<b>TO:</b>	Helen Donaldson, Senior Planner	<b>DATE:</b>	7/2/2018
<b>FROM:</b>	Michael Guethle, PE; Ryan Wingard, PE	<b>PROJECT NO.:</b>	13982B
<b>SUBJECT:</b>	St. John St. - 222; MMC Parking Garage (PL-000207-2018)

Wright-Pierce has reviewed the Level III Site Plan Application information provided for the Employee Parking Garage redevelopment proposed at 222 St. John Street. The project will include redeveloping an existing parking lot into a nine-level parking garage with approximately 2,400 parking spaces; redeveloping another existing parking surface to provide a pedestrian access and vehicle access to levels 1-8 of the building; and redeveloping a third parking surface to provide 52 additional spaces of surface parking. Off-site improvements to St. John Street and D Street are also included in the proposed work. The work will reduce the total impervious surface square footage on the property by 14,506 SF.

GRADING & DRAINAGE PLAN - 2

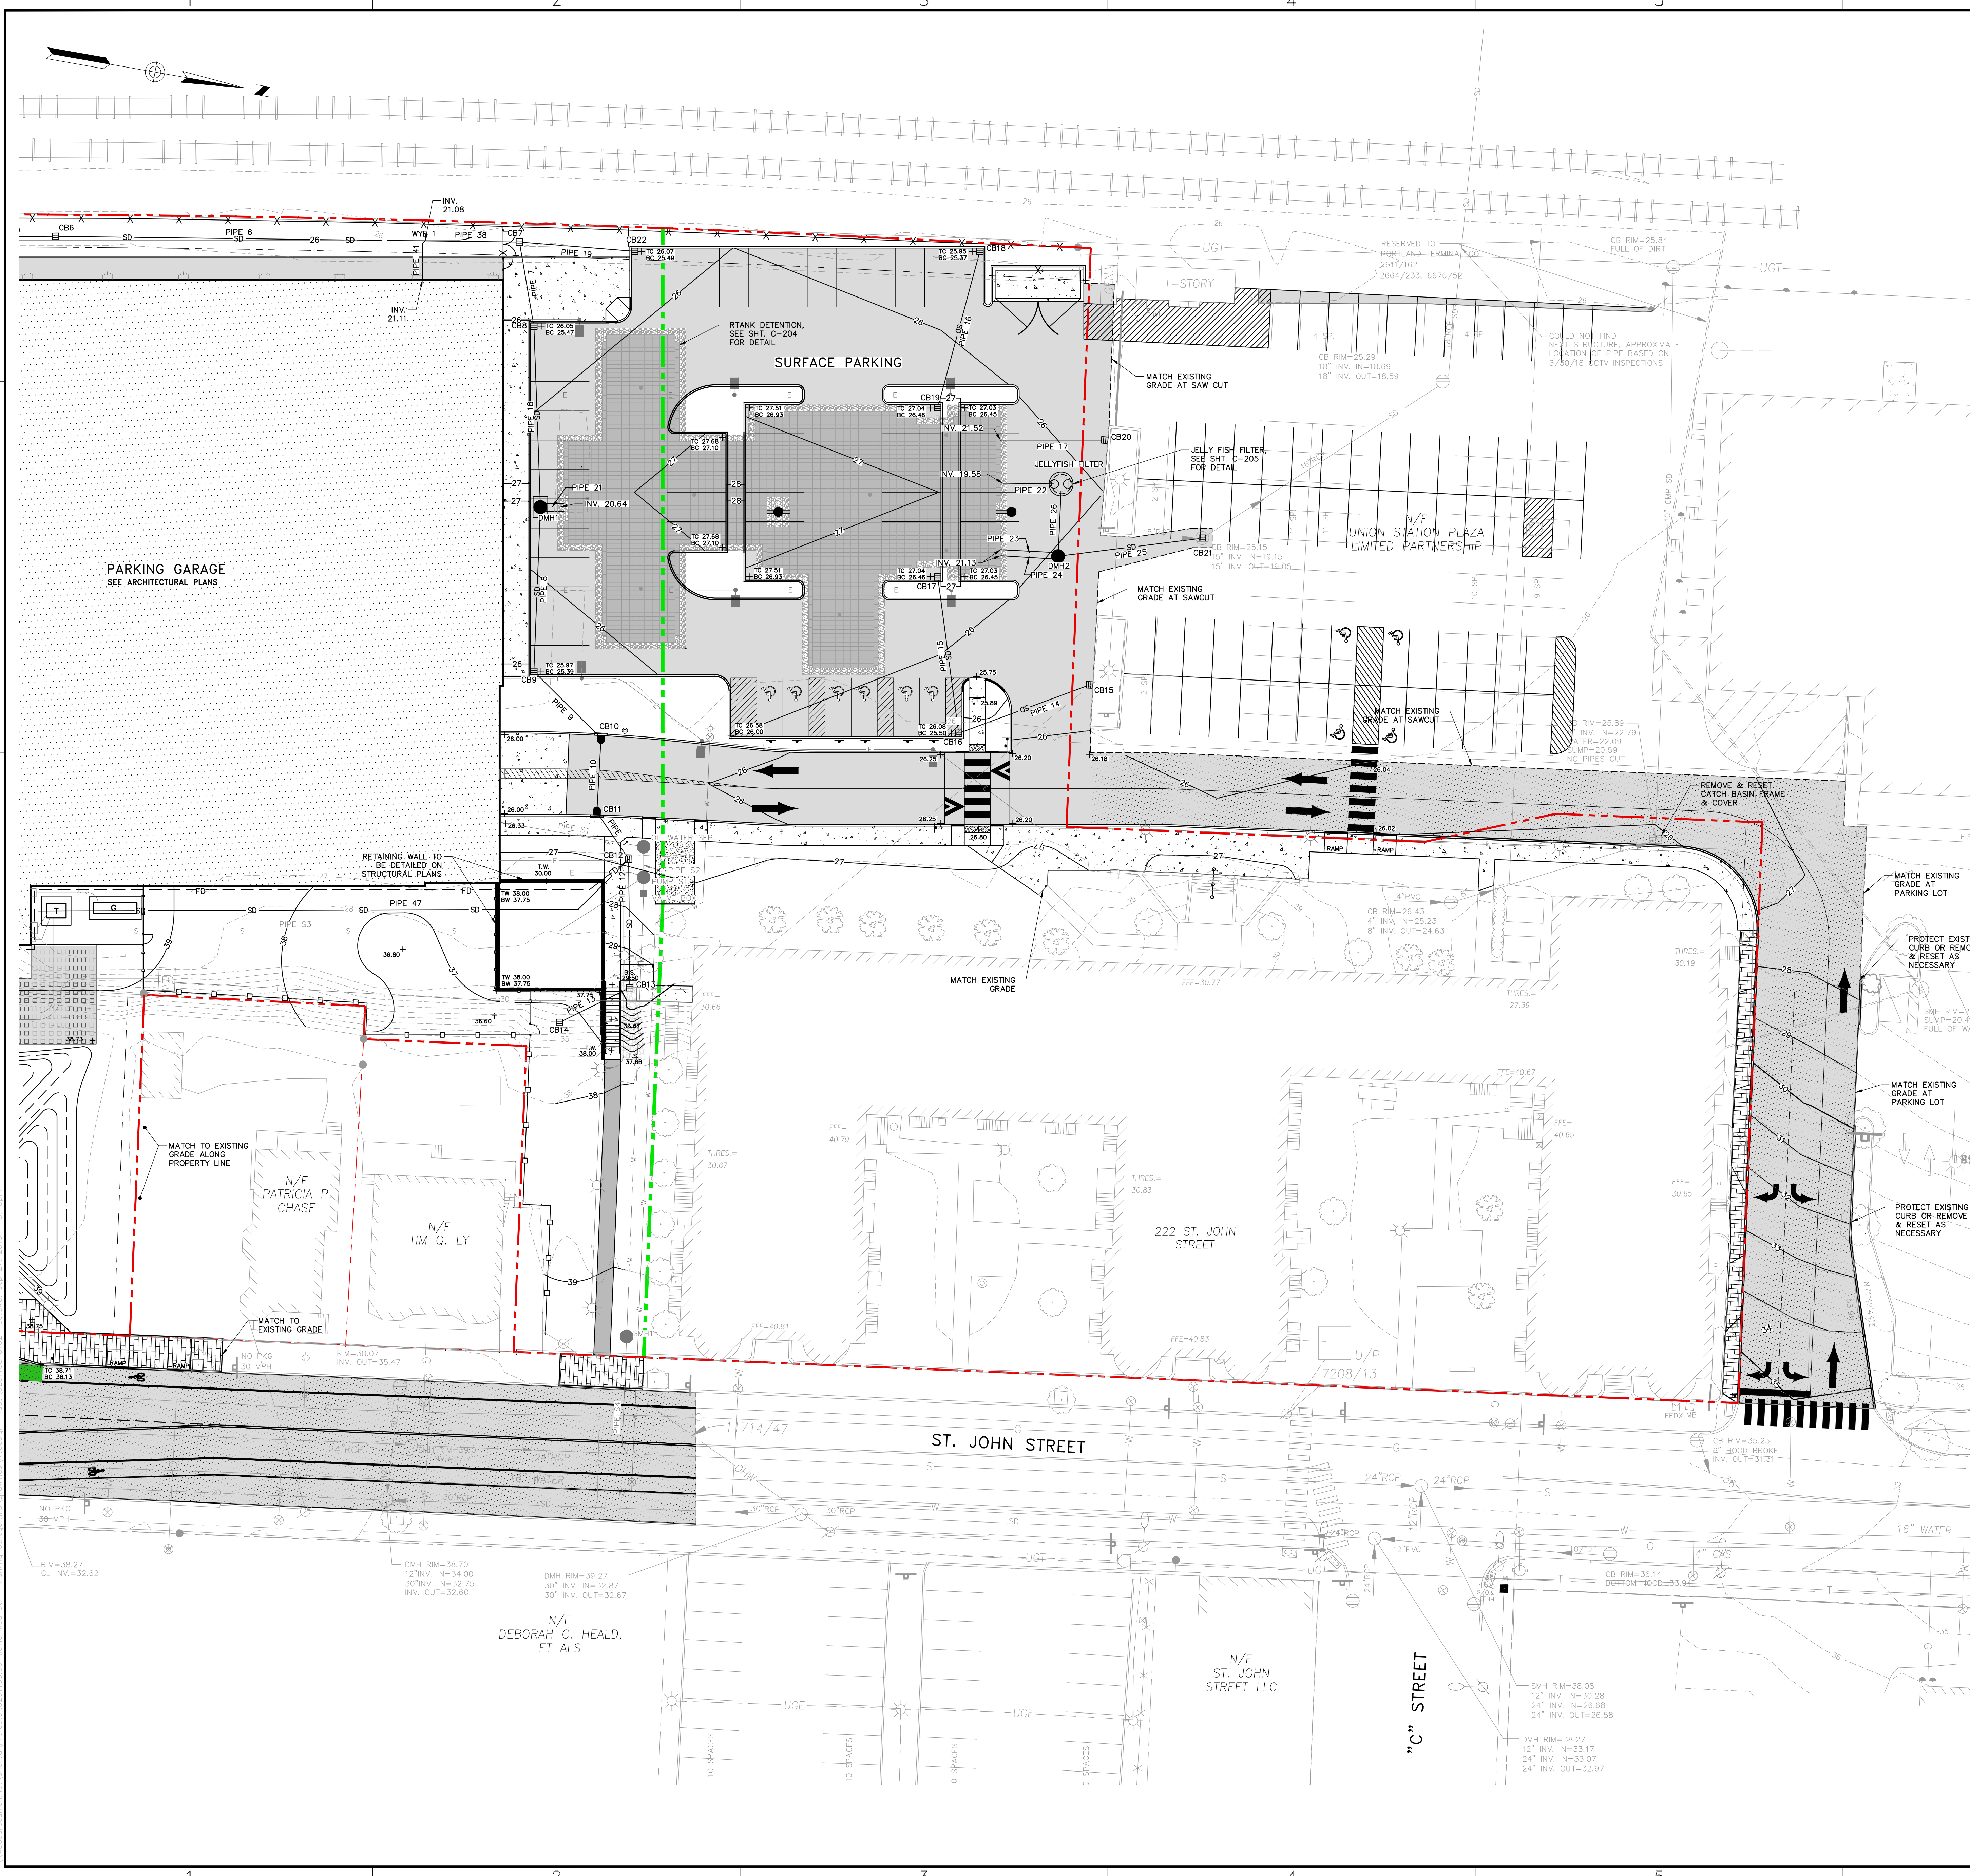
- c. CB21 on sheet C-103 calls out a 15" pipe out of the structure, but the existing pipe between CB21 and the existing CB is referenced as 18". Please confirm the existing pipe is indeed an 18" pipe.

- d. Pipe 22 has a 0.0% slope. Confirm this is the intended design or if the pipe should be sloped to the JellyFish Filter.
- e. CB12 has 1.37 feet of drop between the in and out inverts. Confirm this is the intended design or if the standard 0.1-foot drop is more appropriate.
